Subject: Eagle Rising SF2225 Plat Filing 1 Response Letter and EDARP Upload

Our responses to the EPC October 2, 2024, and October 3, 2024 Plat and related documents review comments have been uploaded EDARP.

| EDARP Review Comments | | | | | | | | | | | | | | |
|-----------------------------------------------------|-------------------------------------|--------------------------------------|-------------|--------------------|-----------------|------------------|------|------------------------------------------------------------------------------------------------------------------------------------------------------------------------------------------------------------------------------------------------------------------------------------------------------------------------------------------------------------------------------------------------------------------------------------------------------------------------------------------------------------------------------------------------------------------------------------------------------------------------------------------------------------------------------------------------------------------------------------------------------

DRAINAGE EASEMENT DETAIL
 LOTS 1 & 2
 SCALE: 1" = 50'

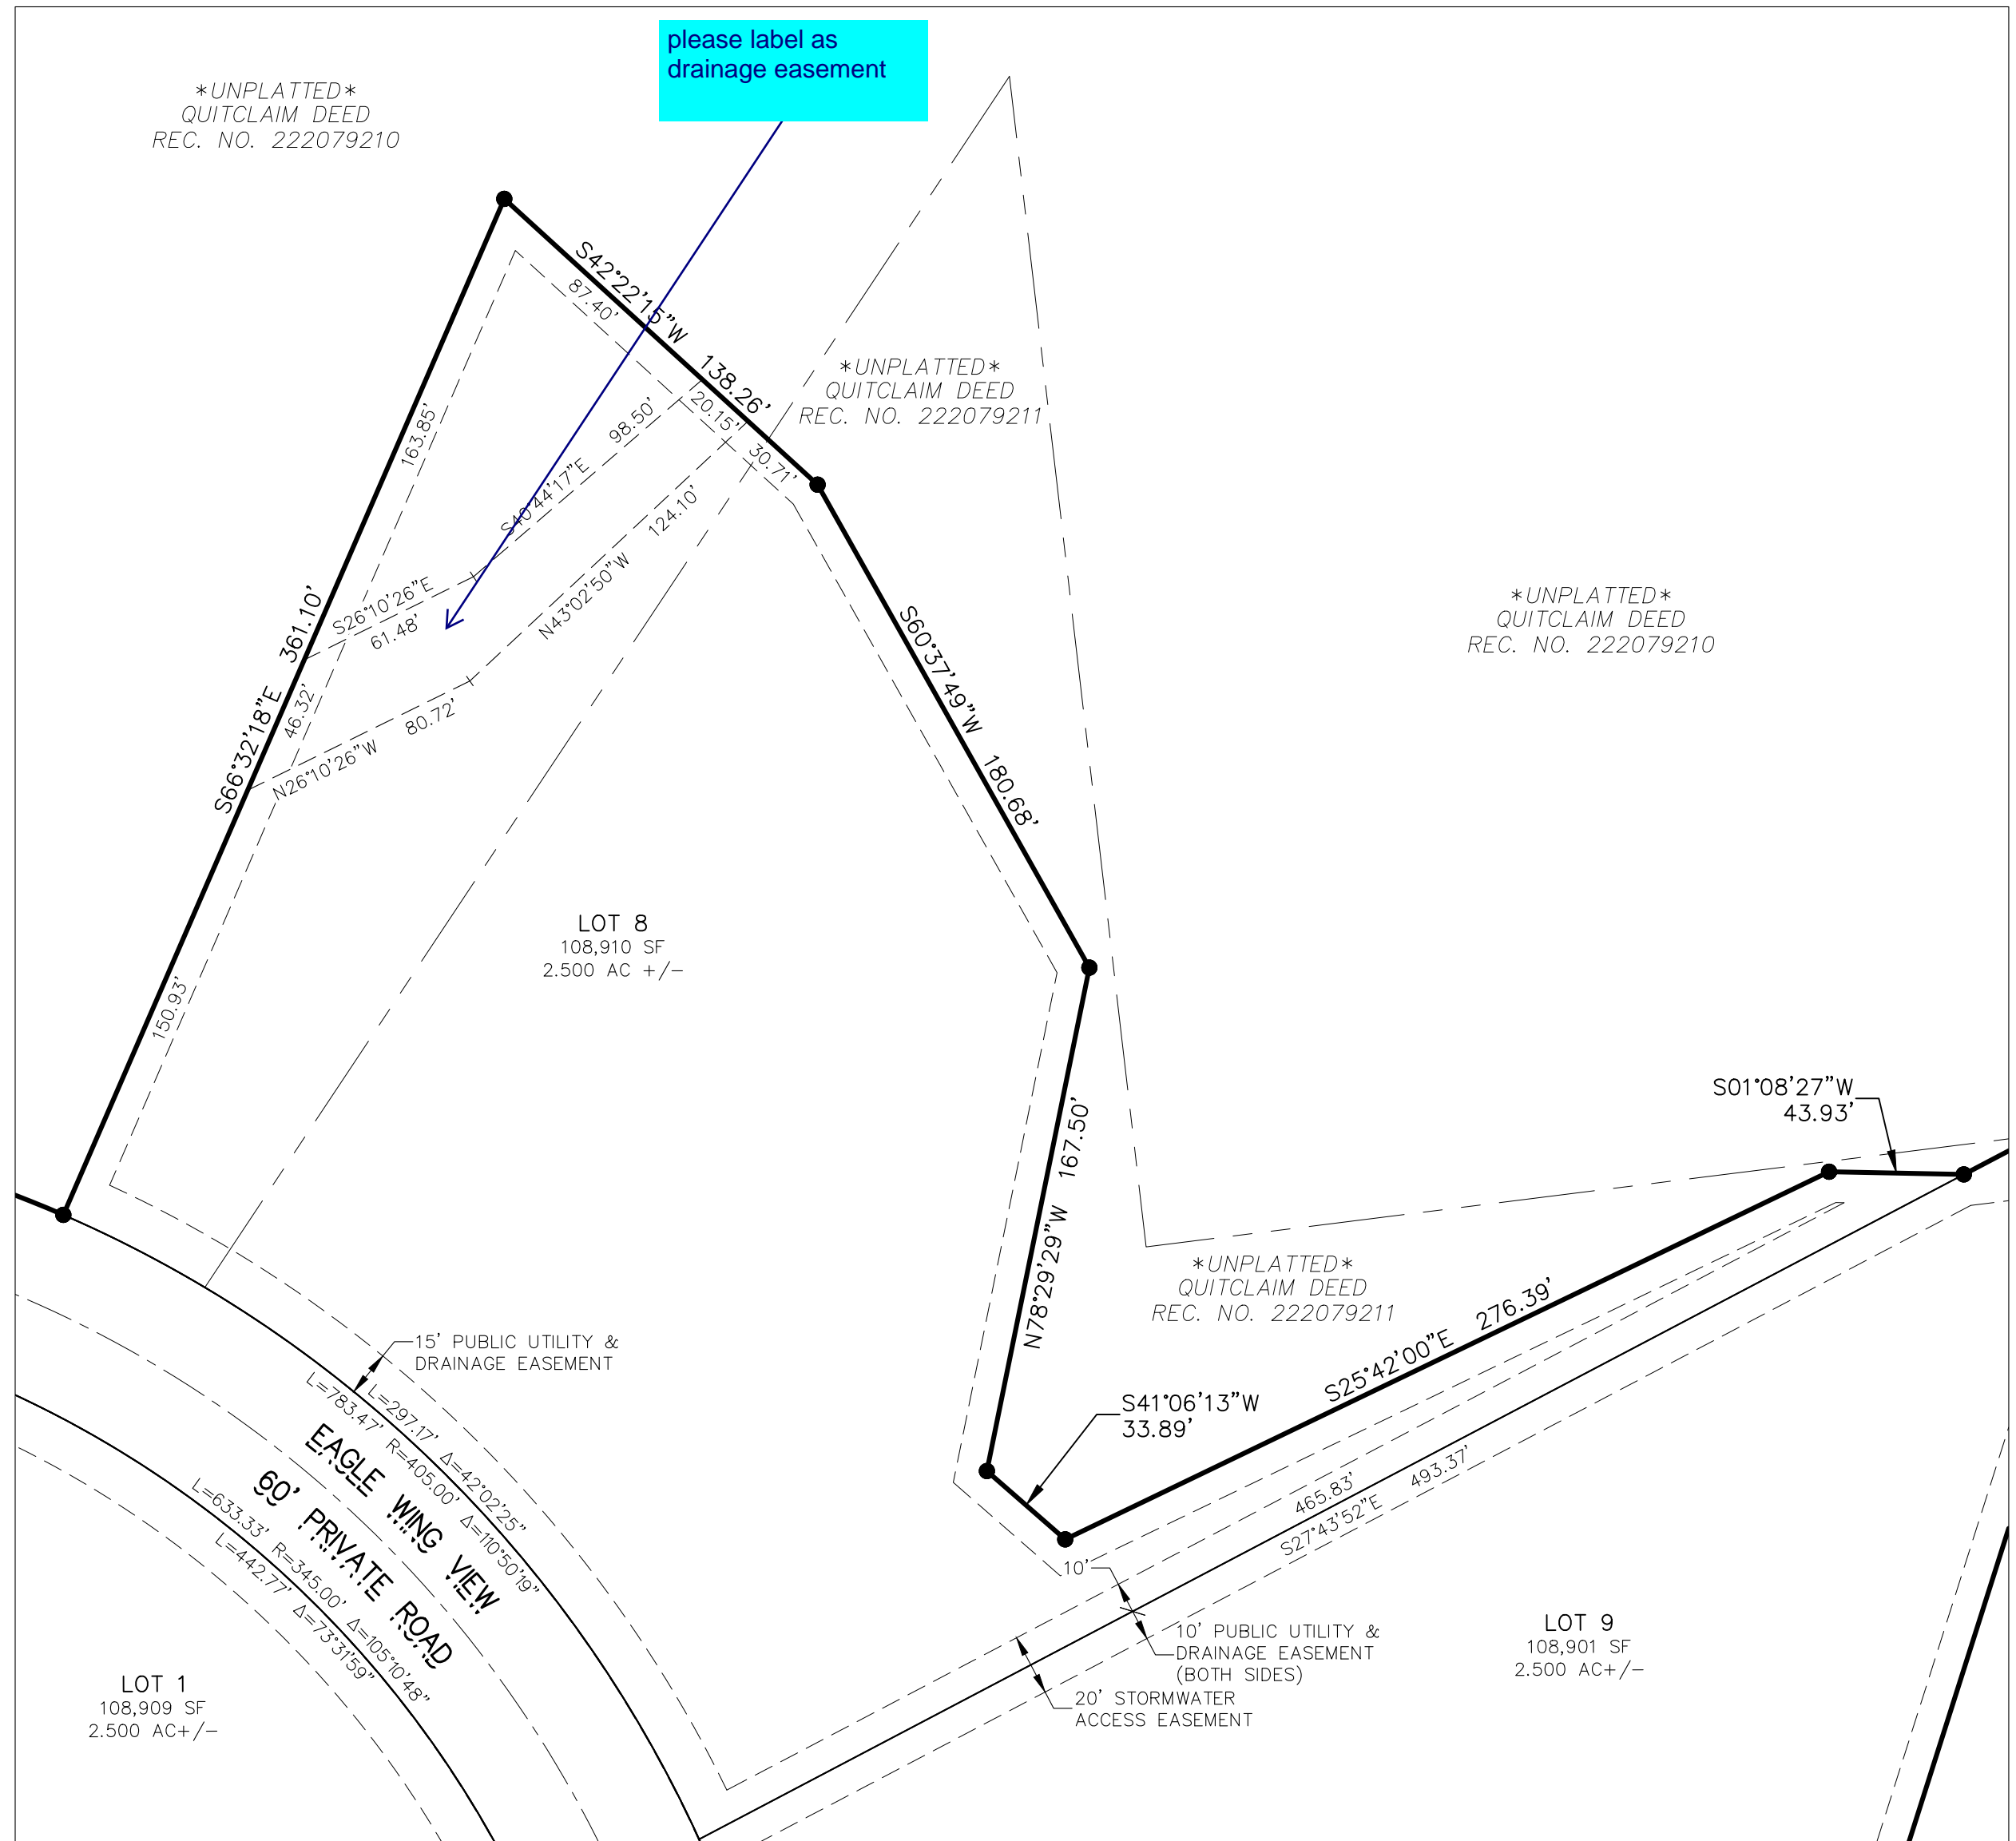
| EDARP Review Comments | | | | | | | | | | | | | | |
|-----------------------------------------------------|-------------------------------------|--------------------------------------|-------------|--------------------|-----------------|------------------|------|----------------------------------------------------------------------------------------------------------------------------------------------------------------------------------------------------------------------------------------------------------------------------------------------------------------------------------------------------------------------------------------------------------------------------------------------------------------------------------------------------------------------------------------------------------------------------------------------------------------------------------------------------------------------------------------------------------------------------------------------------------------------------------------------------------------------------------------------------|------------------------|-------------------------|-------------------------------------|------|--------------------------------------------------------------------------------------------------------------------------------------------------------------------------------------------------------------------------------------------------------------------------------------------------------------------------------------------------------------------------------------------------------------------------------------------------------------------------------------------------------------------|--------------------------------------------------------|
| 14 | Final Plat Eagle Rising Filing No 1 | PCD Engineering Division | Yes | Edward Schoenheit | 10/3/2024 10:53 | (Plat redlines) | 4 | please label as drainage easement | A - Approve | 10/21/2024 | Final Plat Eagle Rising Filing No 1 | 4 | See update | |
